<b>Application Ref:</b>	2025/0531			 Ribble Valley Borough Council <small>www.ribblevalley.gov.uk</small>
<b>Date Inspected:</b>	25/07/2025	<b>Site Notice:</b>	25/07/2025	
<b>Officer:</b>	EP			
<b>DELEGATED ITEM FILE REPORT:</b>				<b>REFUSAL</b>

<b>Development Description:</b>	Proposed erection of single-storey dwelling house (self-build) within existing garden curtilage together with new access and hardstanding and demolition of garage.
<b>Site Address/Location:</b>	Land rear of Pendle Street East Sabden BB7 9FX.

Scale	Sheet Size	Drawing Status
AS SHOWN	A1	PLANNING
Job Number	Drawn By	Checked
24-045	AW	AW
Drawing Number	Revision	Final Issue
PL04	A	-

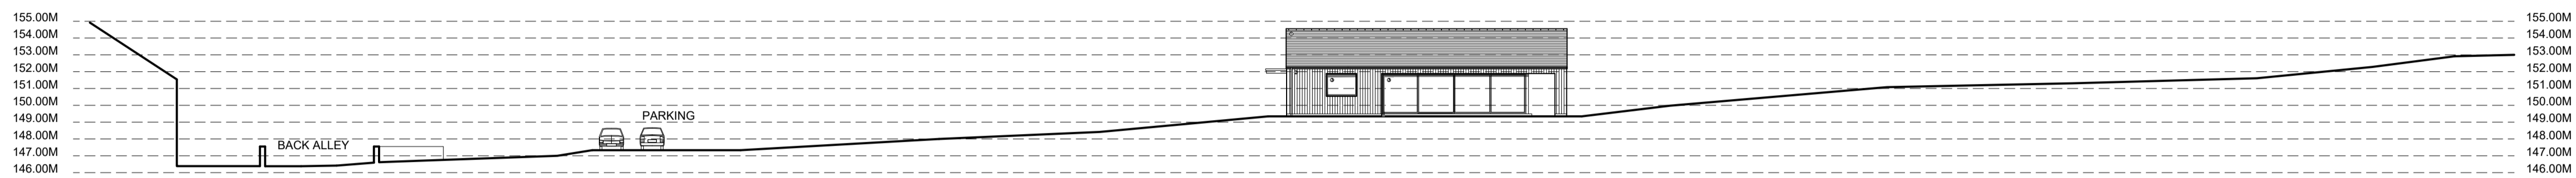
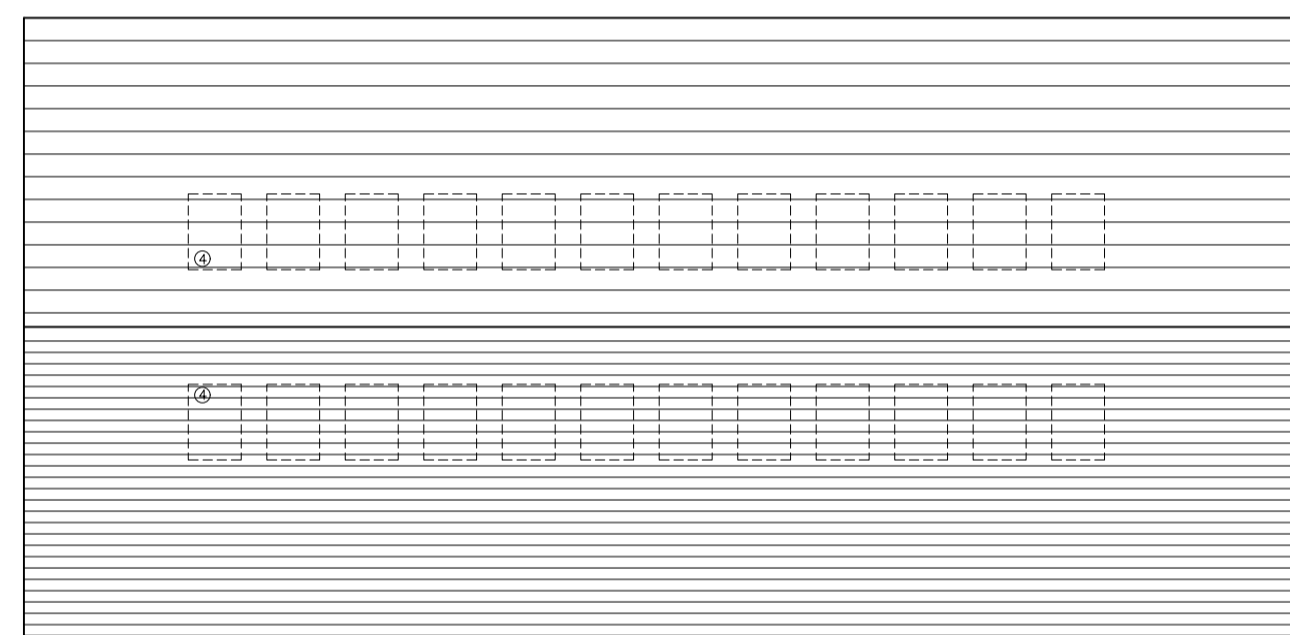
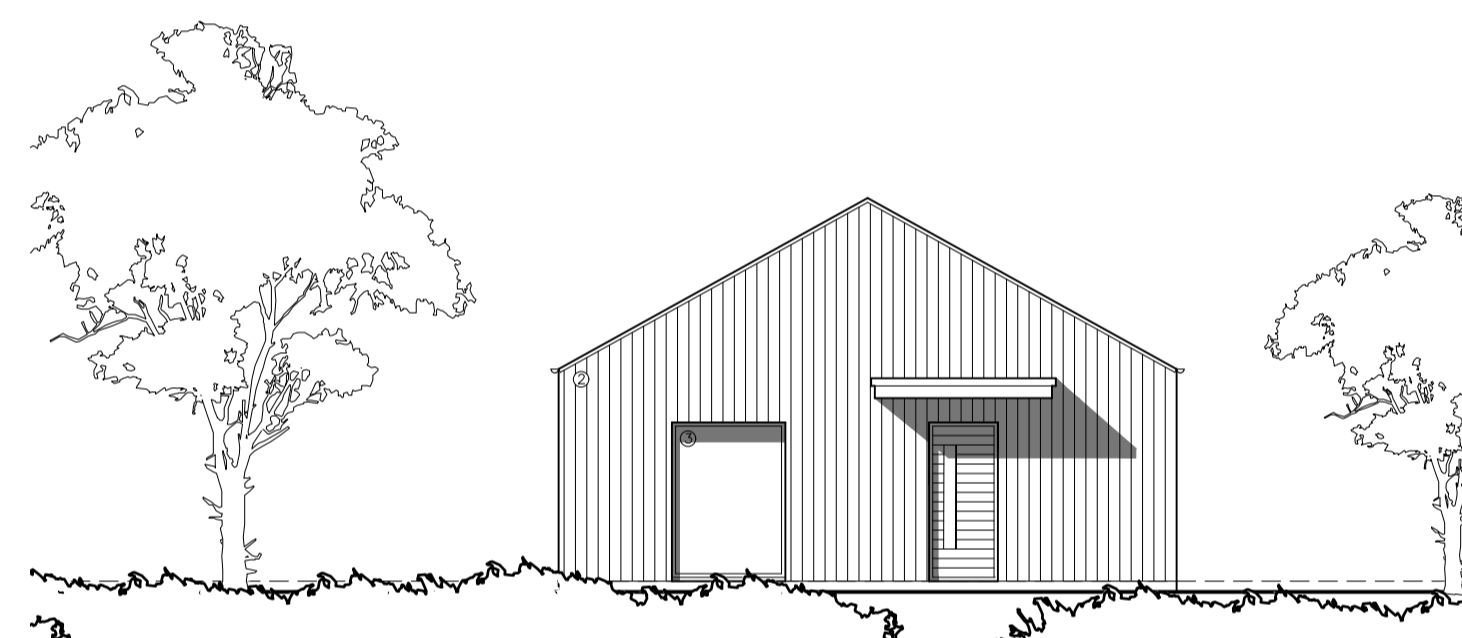
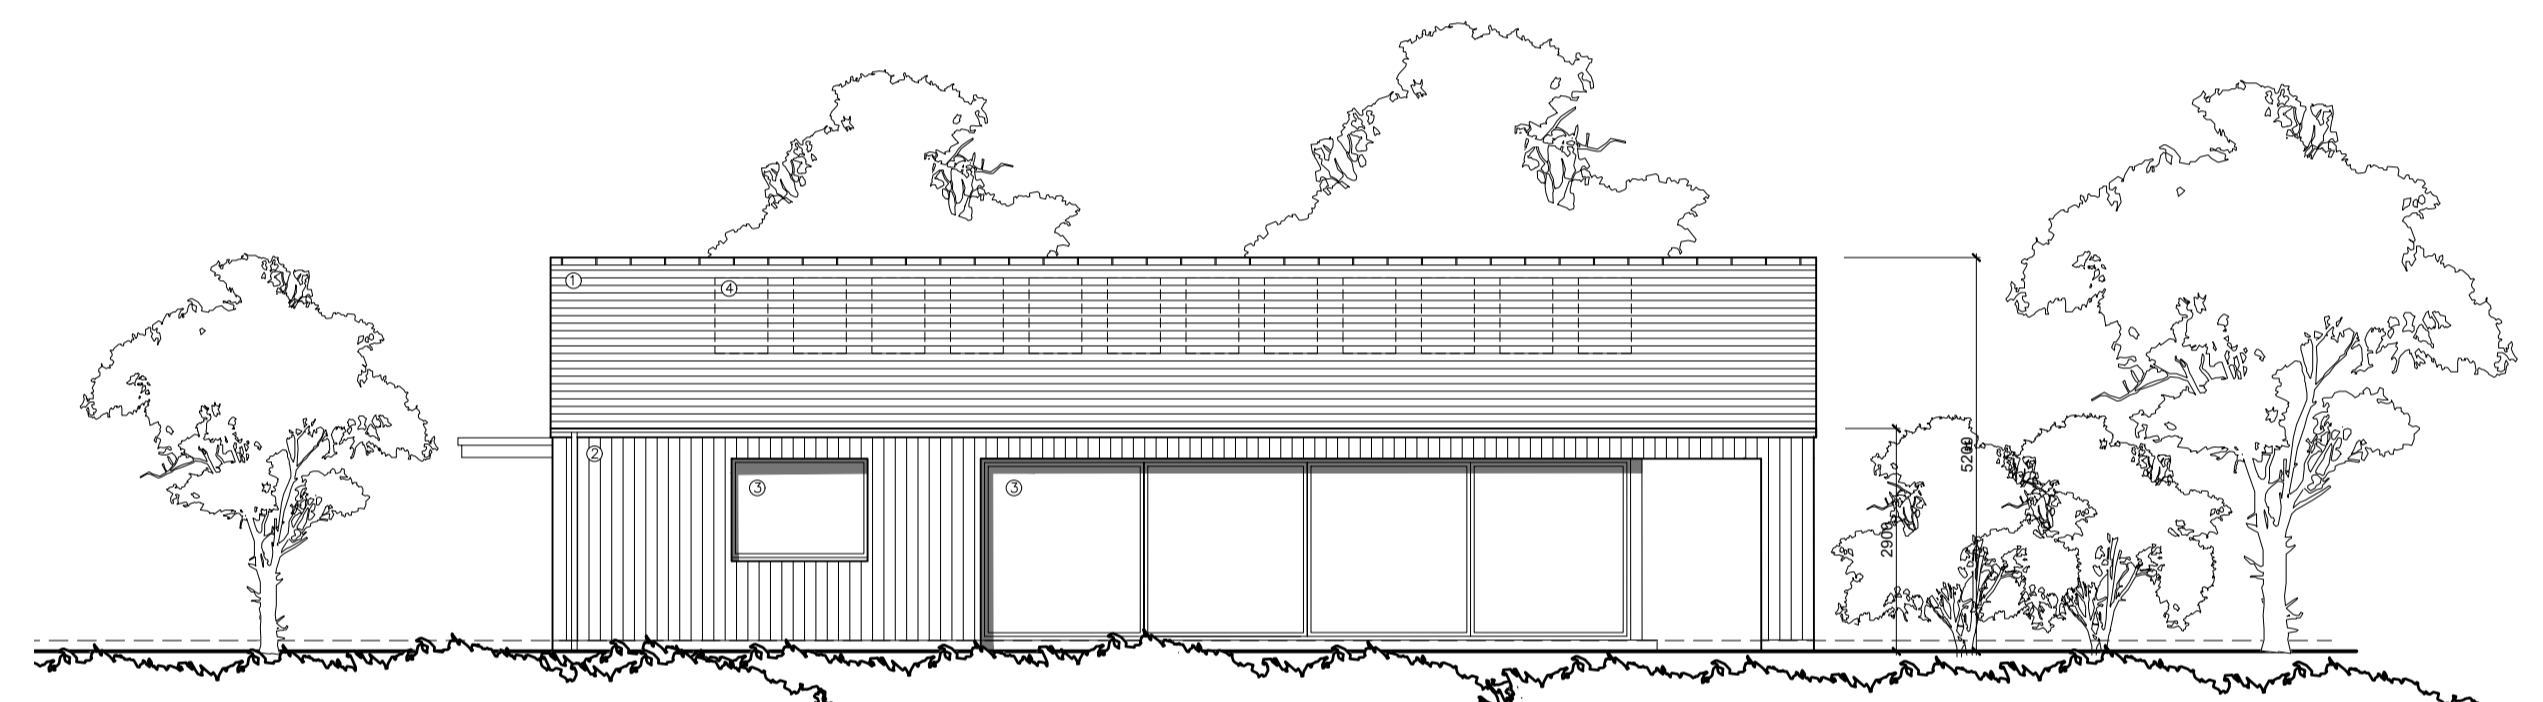
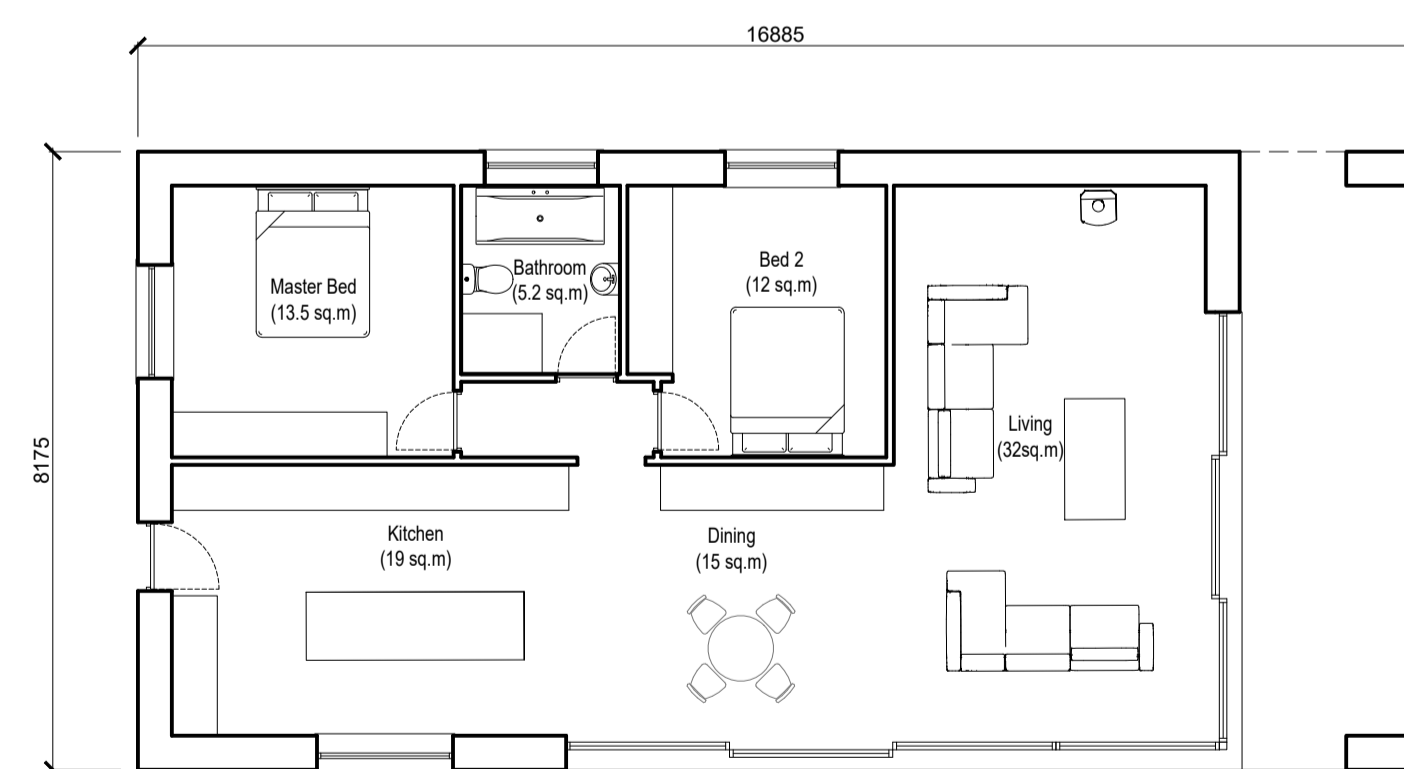
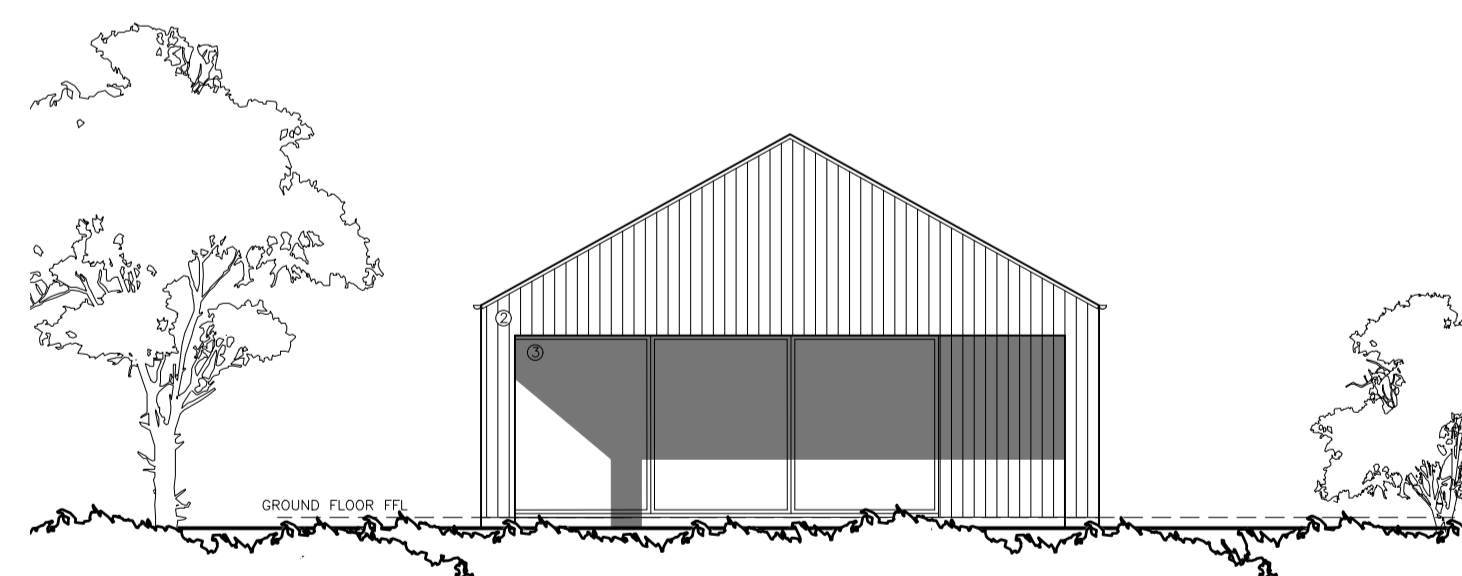
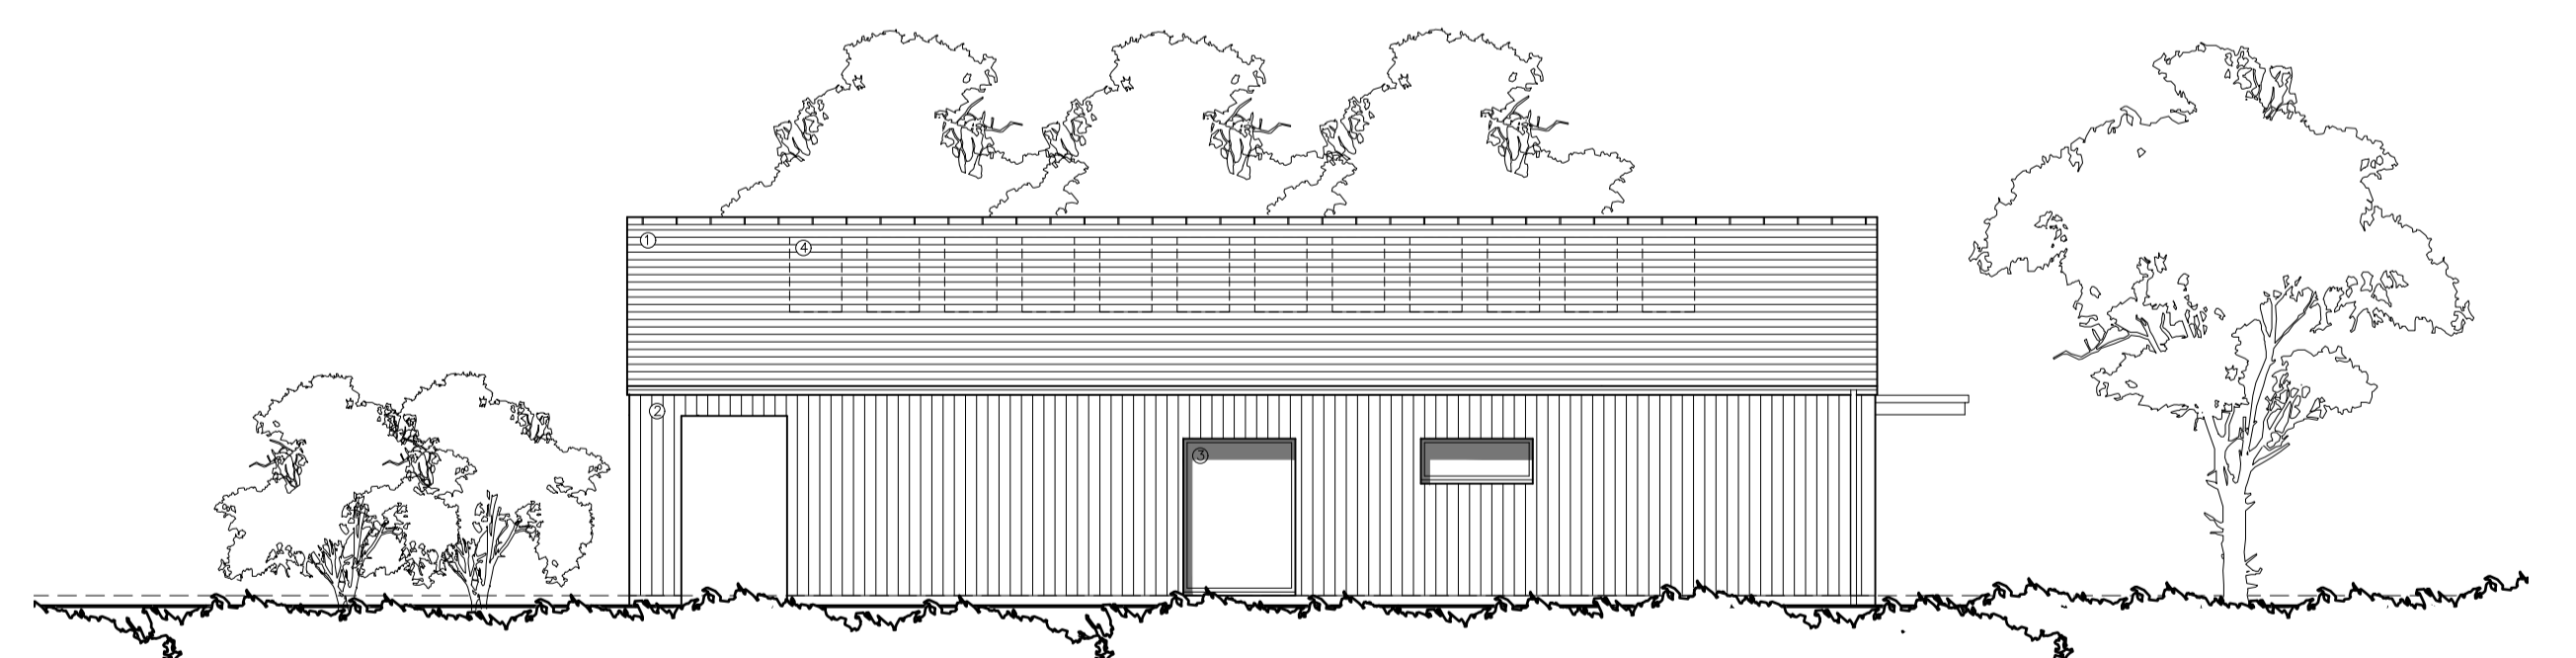
The proposed dwelling is faced entirely in vertical timber cladding. Given the use of mixed materials in the vicinity, the use of some wooden cladding is not opposed. However, the introduction of a building entirely clad in timber and with a significant level of glazing is at odds with the surrounding built form. As proposed the design is not considered appropriate to the location, being within the National Landscape.

Based on the above assessment, the development conflicts with Key Statement EN2 and Policy DMG1 of the Ribble Valley Core Strategy by virtue of the proposed siting, layout and building design including choice of materials which conflicts with existing vernacular and the character of the National Landscape.
